DOC21/1142757-11

EPA Advice on Revised Submissions Report – Addendum Noise Impact Assessment

Thank you for the request for advice on 23 December 2021 from Public Authority Consultation (PAE-34237526), requesting the review by the NSW Environment Protection Authority (EPA) of the Revised Submissions Report for the Sell & Parker Pty Ltd (the Proponent) proposed Kings Park Metal Recovery and Recycling Facility Expansion (SSD-10396) (the Proposal) at 23-43 and 45 Tattersall Road, Kings Park (the Premises).

Figure 2 – Site, noise monitoring and receiver locations

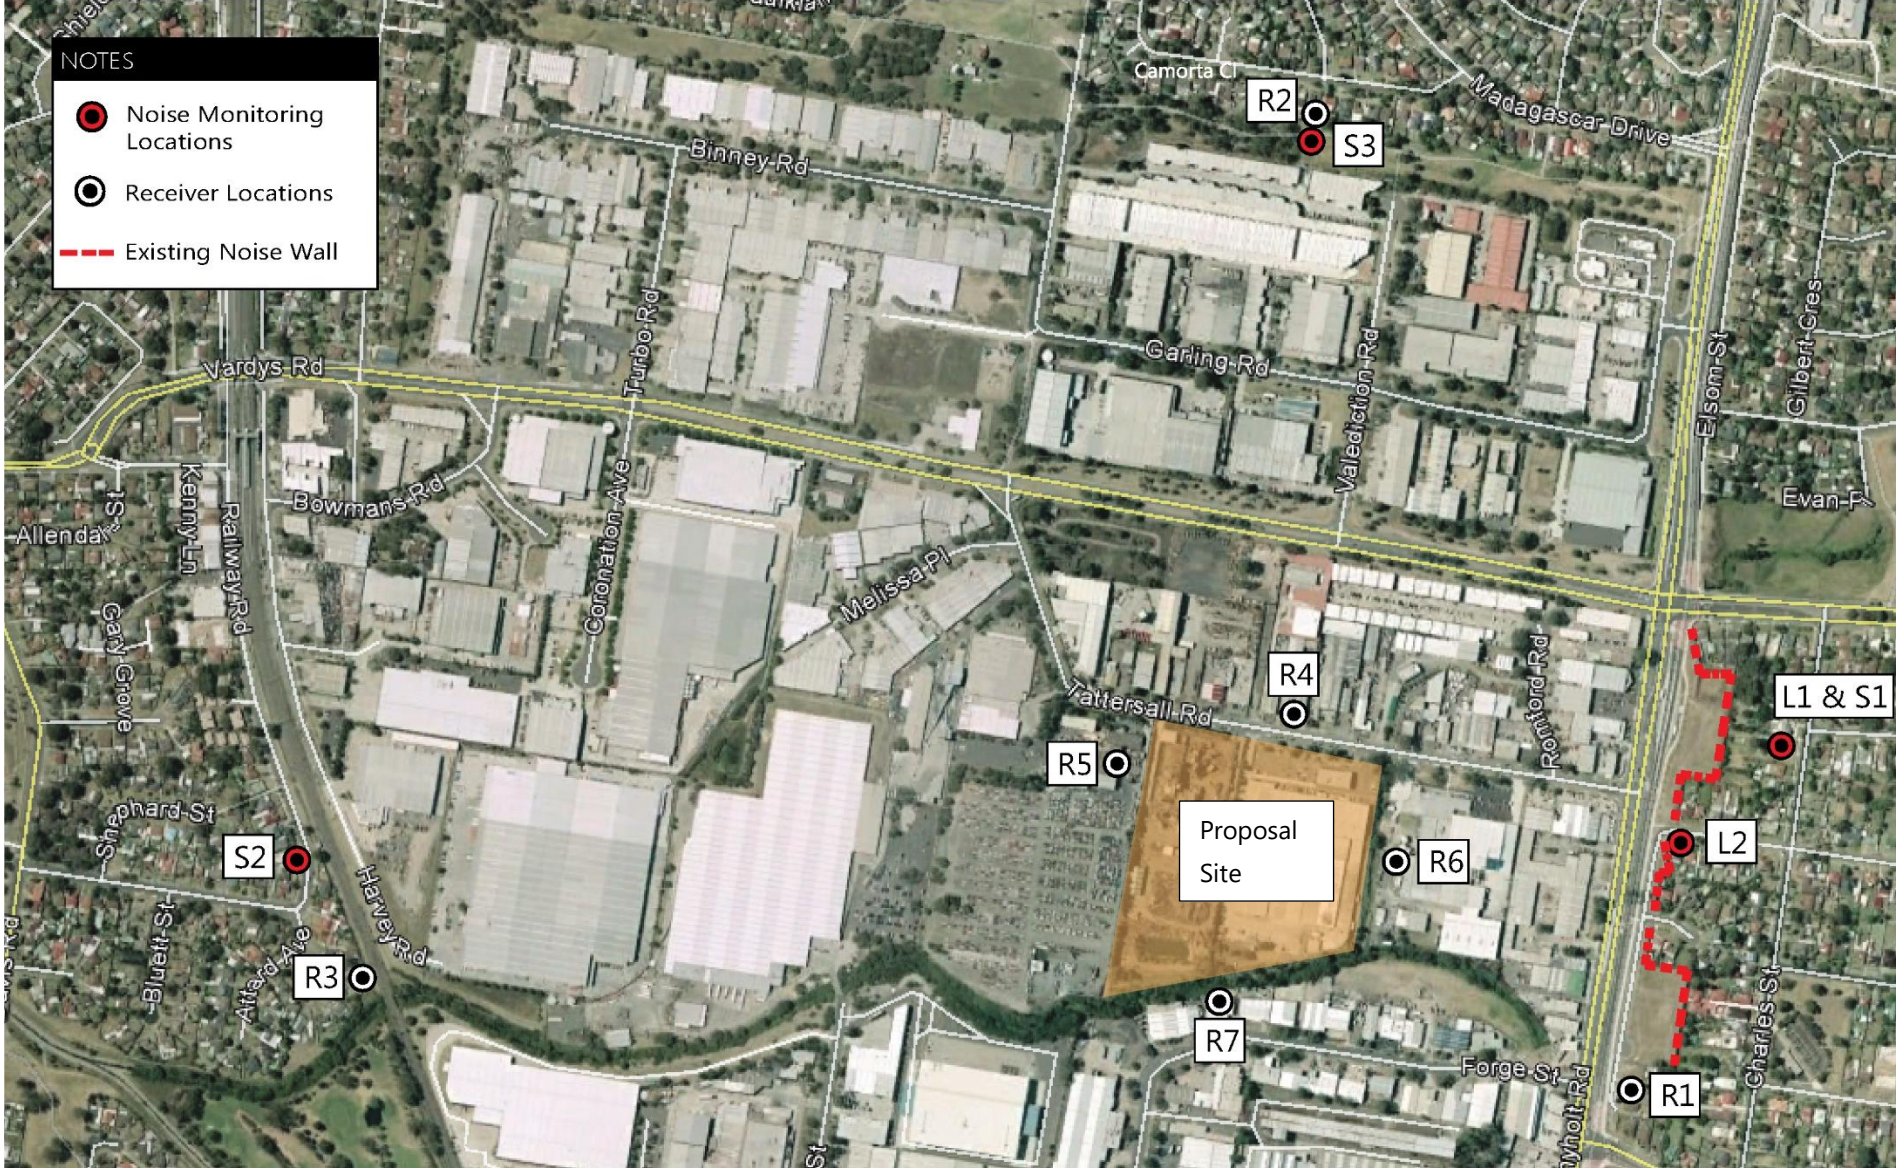
a. Model validation using L_{Amax} events

Section 7.2 of the Addendum NIA indicates that the Premises is periodically audible at the residential locations to the east (Charles and Anthony Street Blacktown), however a clear signal could not be obtained for a fifteen minute period to obtain an L_{Aeq,15minute},dB level.

The Addendum NIA has relied on noise model validation at the Premises' eastern and western boundaries. Validation at points so close to the activities under consideration has limited utility given that factors in the model such as ground absorption, atmospheric absorption, barrier effects, topography, meteorology are not being validated at such close locations.

Maximum noise events to the east of the Premises are the major source of concern for the community. As these are being predicted by the model, the EPA considers it appropriate to validate the noise model by capturing L_{Amax} events at the residential receivers to the east of the Premises.

The DPE has informed the EPA that a DPE officer undertook noise measurements in the vicinity of 13 Anthony Street Blacktown in the morning shoulder period on Friday 28/1/2022. The DPE officer recorded L_{Amax} levels correlated with audible events purportedly from the Premises in the range of 55-76dB. These measured levels significantly exceed the predicted L_{Amax} levels (predicted upper level of L_{Amax} 50dB) in the Addendum NIA for that location. This highlights the need for effective noise model validation to ensure that impacts are accurately reported and appropriate mitigation measures considered.
